WEST SUSSEX COUNTY COUNCIL CONSULTATION

TO:	Arun District Council FAO: Simon Davis
FROM:	WSSC - Highways Authority
DATE:	11 September 2019
LOCATION:	The Former Ship Inn Aldwick Street Aldwick PO21 3AP
SUBJECT:	AW/237/19/PL Application for variation of conditions imposed on planning reference AW/211/14/PL relating to condition 8 - delivery times & Condition 10 - delivery of goods serving the store in accordance to the Delivery Management Schedule.
DATE OF SITE VISIT:	n/a
RECOMMENDATION:	More information
S106 CONTRIBUTION TOTAL:	n/a / £ See below for breakdown.

Client
One Stop Stores Limited
Project
The Former Ship Inn, Aldwick Street, Bognor Regis. PO21 3AP
Title
Site Location an Block Plan

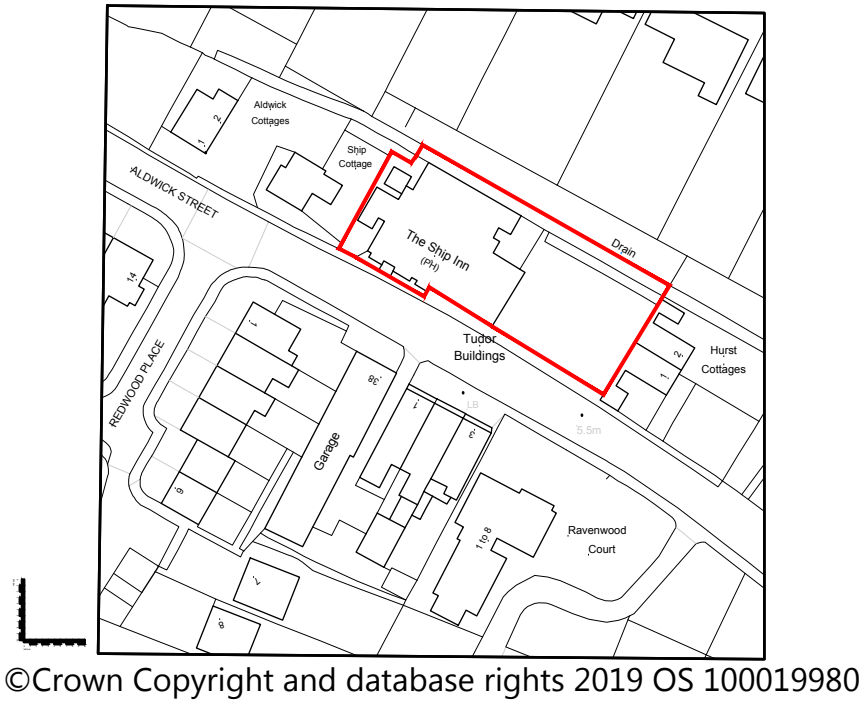
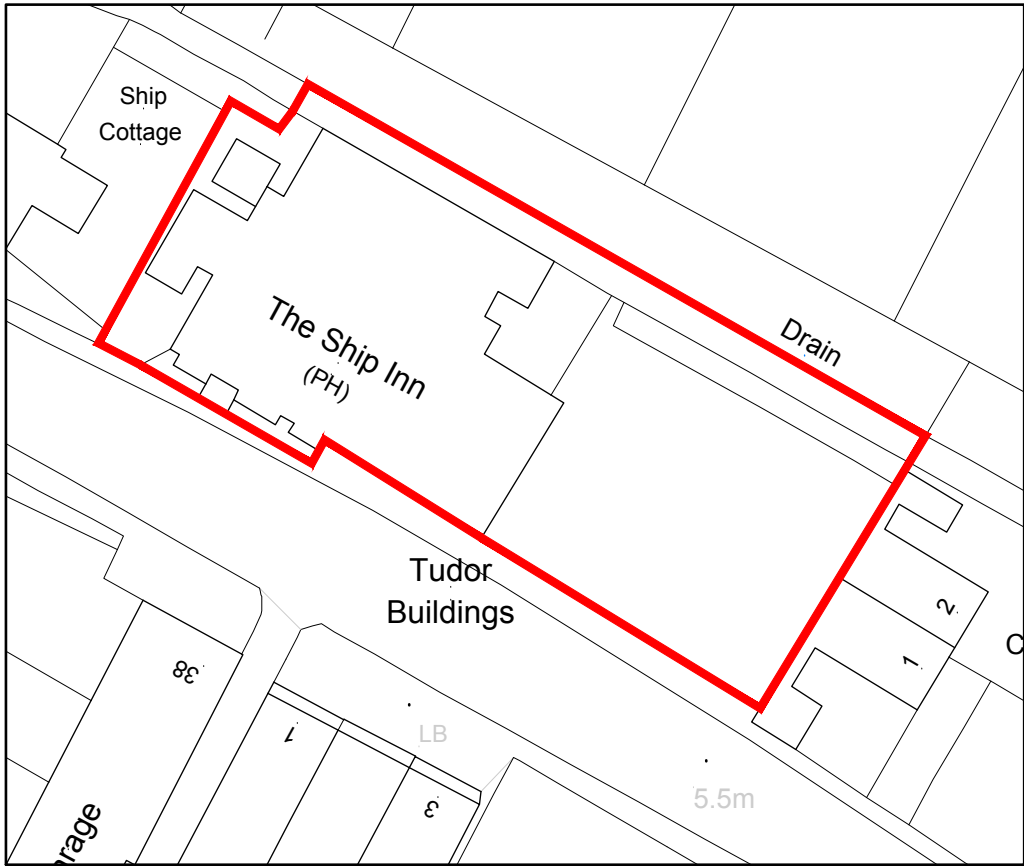
- 1) Sizes for all proposed vehicles
- 2) Anticipated daily numbers of vehicles over the course of a week (we understand from the submitted delivery plan this will be 35 weekly)
- 3) A location plan showing where loading/unloading will take place.

Title
Site Location Plan with Vehicle Tracking : Articulated Vehicle

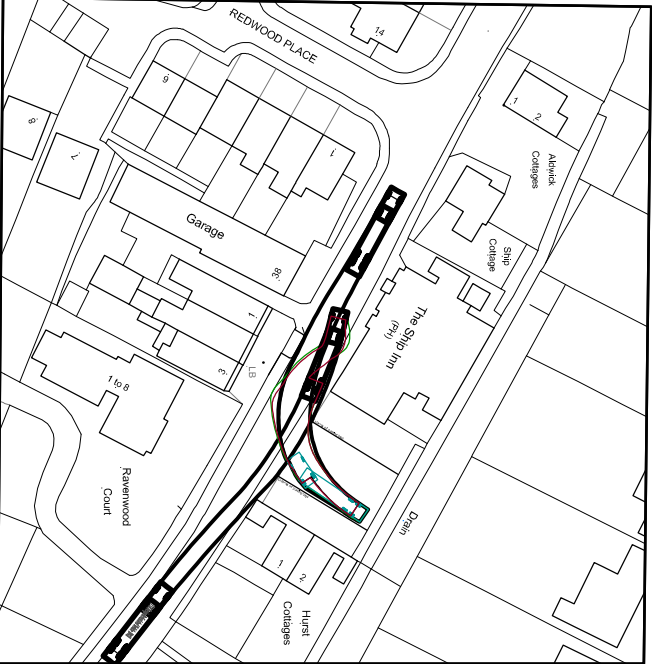
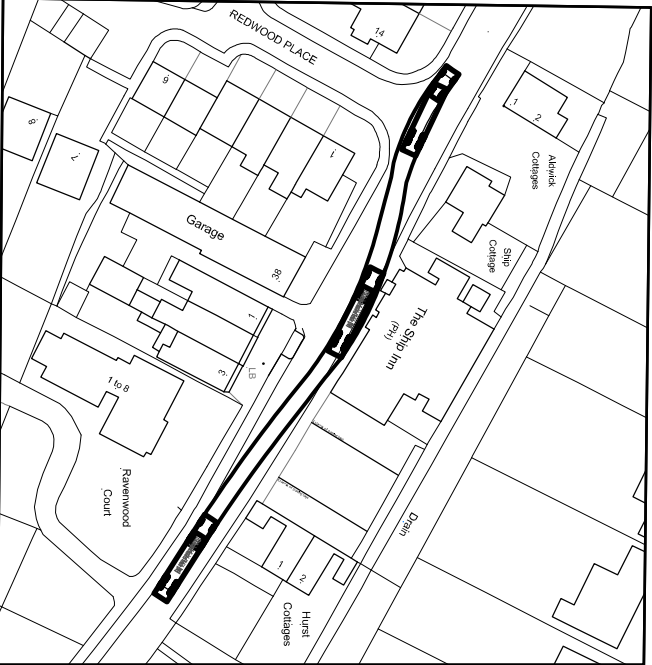
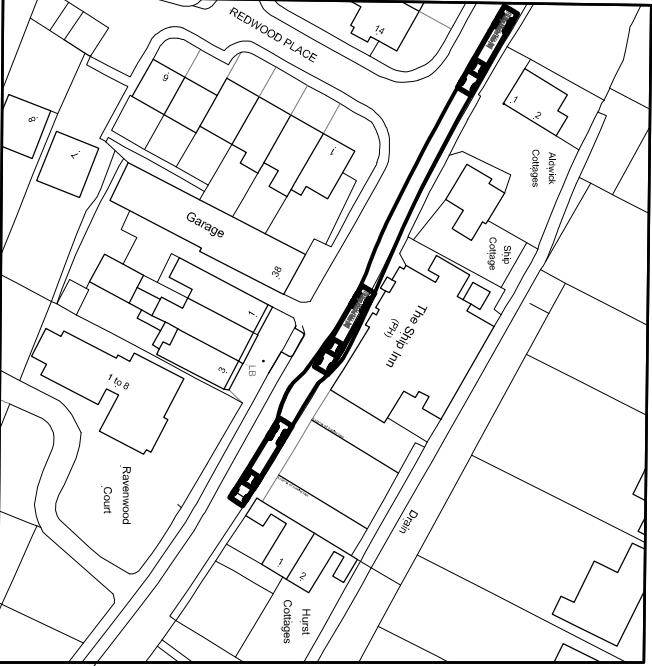
- 4) Swept paths to shown how the different sized vehicles can use the existing site.
